**48 Westbury Road,
New Malden,
KT3 5AX**

Design and Access Statement
in support of the
planning application

TOWN AND COUNTRY PLANNING ACT 1990 (AS AMENDED)
RE: 48 Westbury Road New Malden KT3 5AX

PROPOSAL: Erection of single storey rear extension, part single/part two storey side extension, and hip to gable and rear dormer roof extension to facilitate loft conversion.

16.10.23	FOR PLANNING	AD/2306/24	1:50 @ A1 1:100 @ A3	1

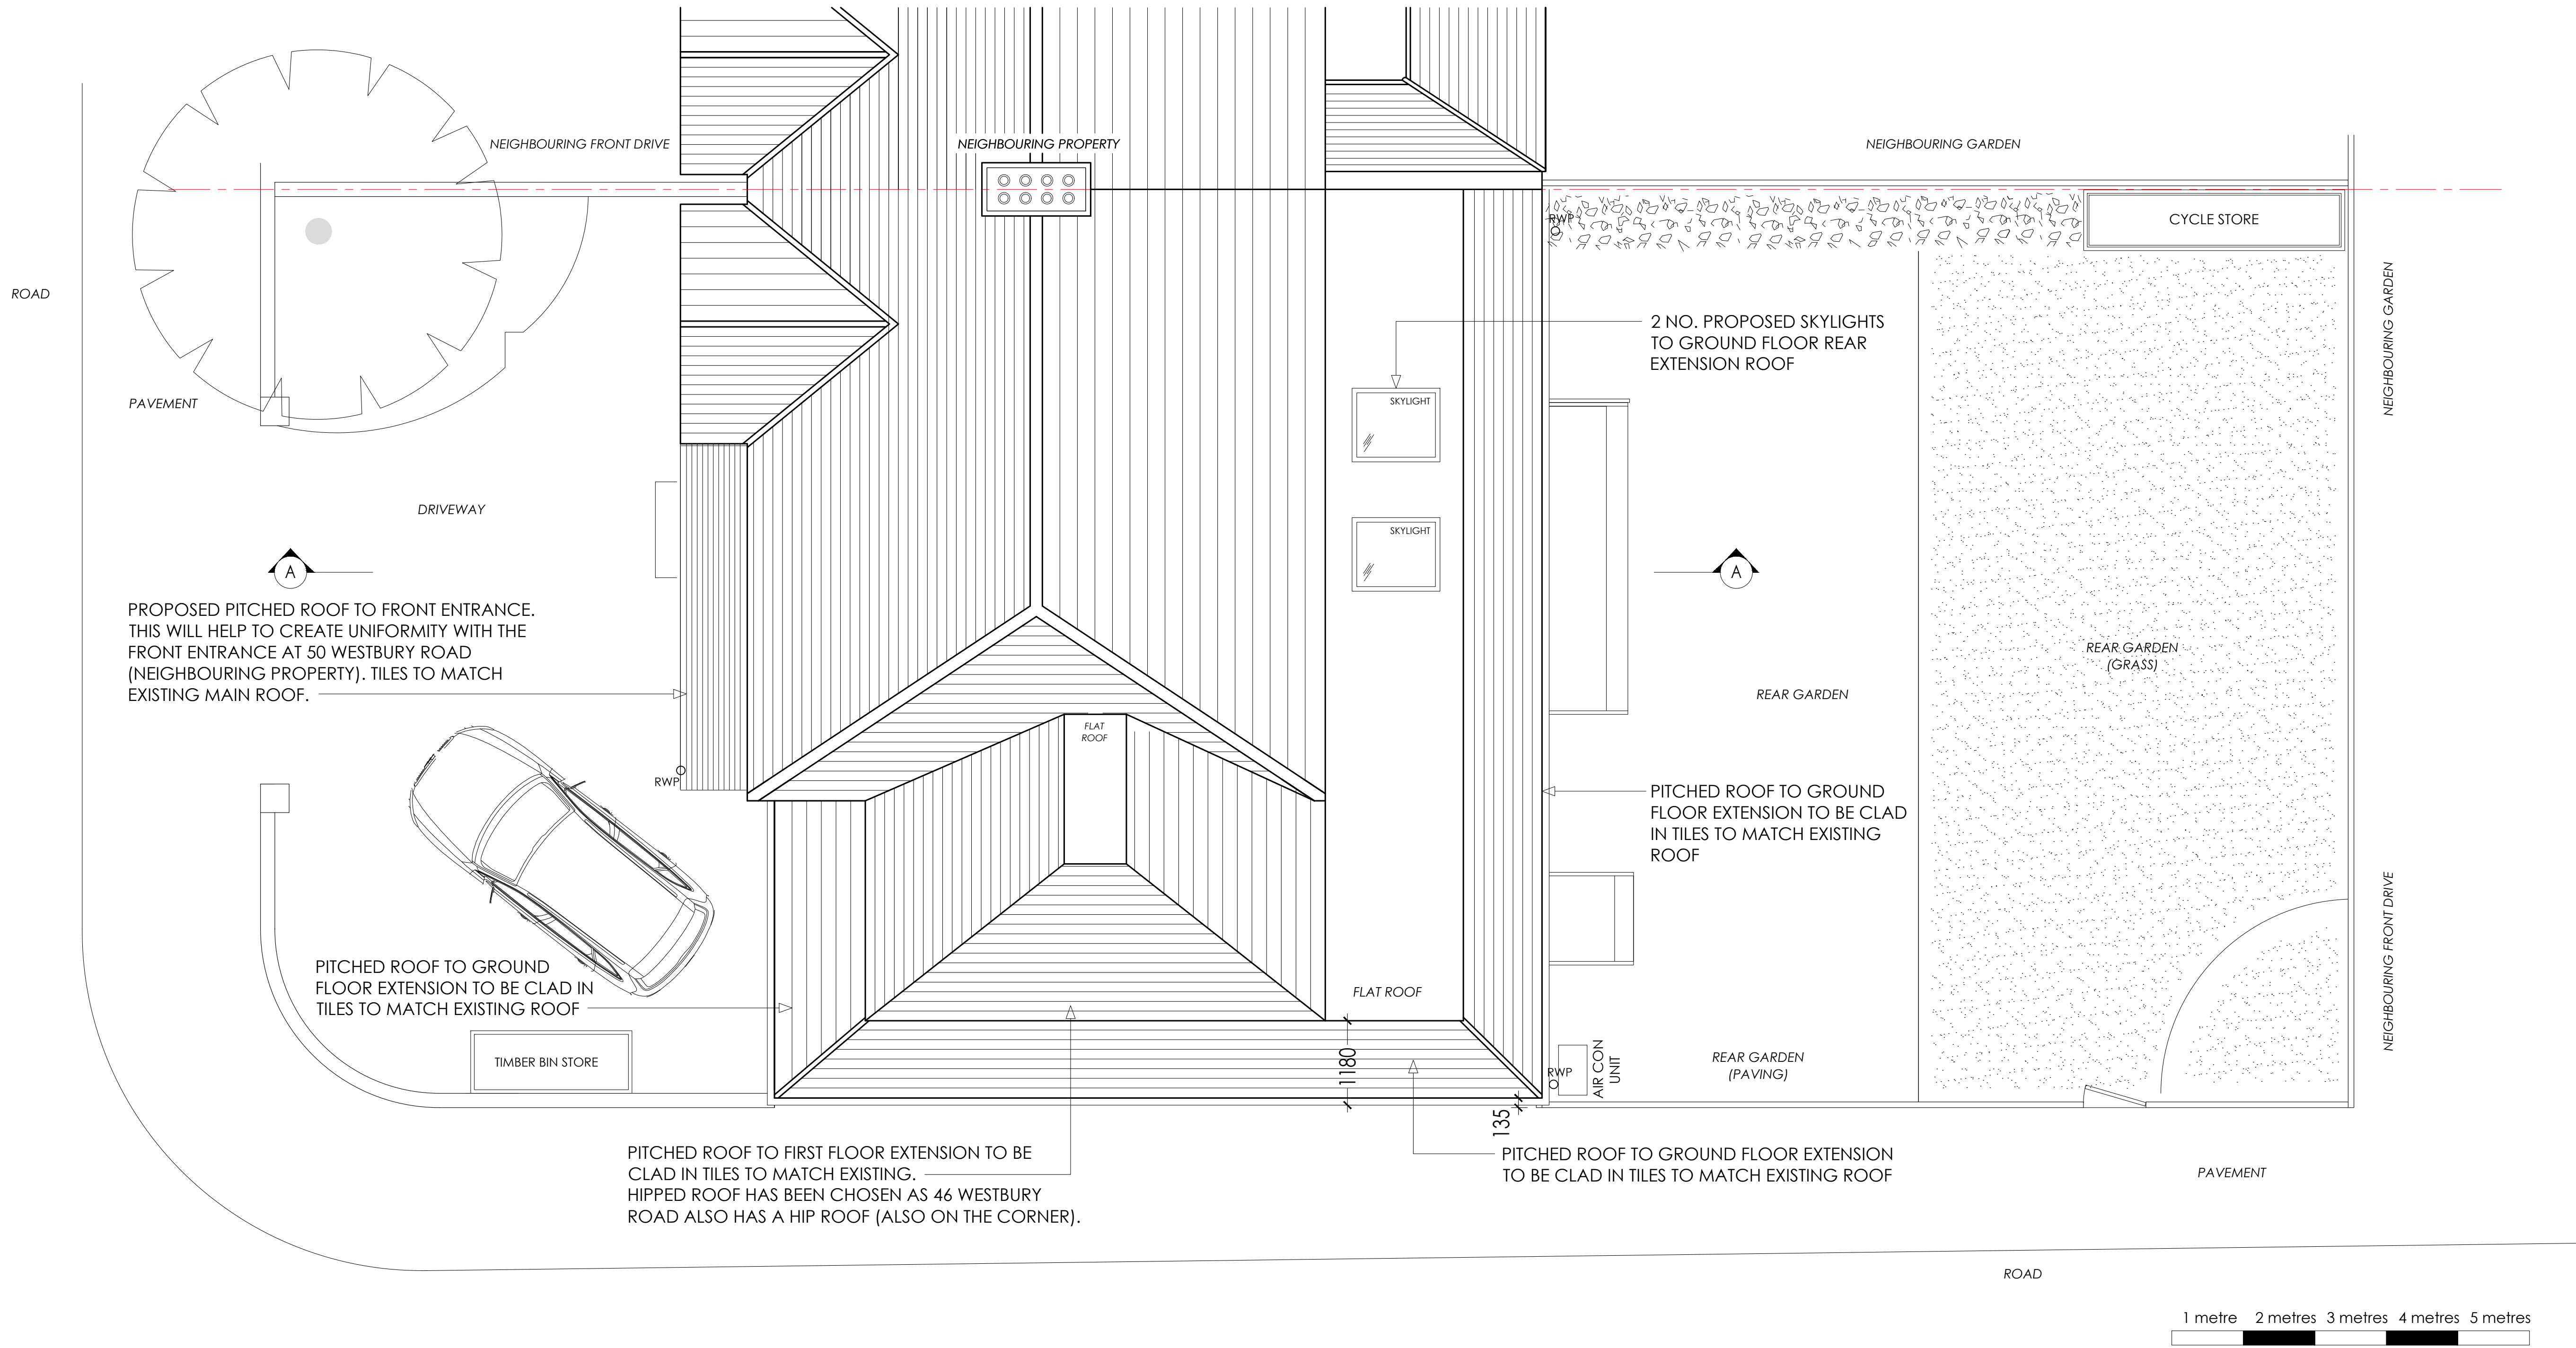
It is considered that the proposed hip to gable roof extension would not accord with the policy Guidance as it would upset the symmetry with the adjoining property. Furthermore, the proposed hip to gable would introduce another roof form that would not be in-keeping with other hipped roof forms.

The proposed rear dormer roof extension due to its inadequate set down and set in distances, excessive scale, mass and bulk would appear as a dominant and disproportionate addition to the host dwelling and surrounding area, in conflict with Policy Guidance 39.

A rear dormer roof extension to follow Policy Guidance 39 should be set down from the existing roof line and set in from the eaves of the roof by at least 500mm.

With regards to the proposed front dormer window, Policy Guidance 39 does not recommend locating a dormer window on the front roof slope.

The proposed front dormer window as shown on the submitted drawings, due to its excessive scale, proposed roof design and materials would unlikely to be supported by Officers.
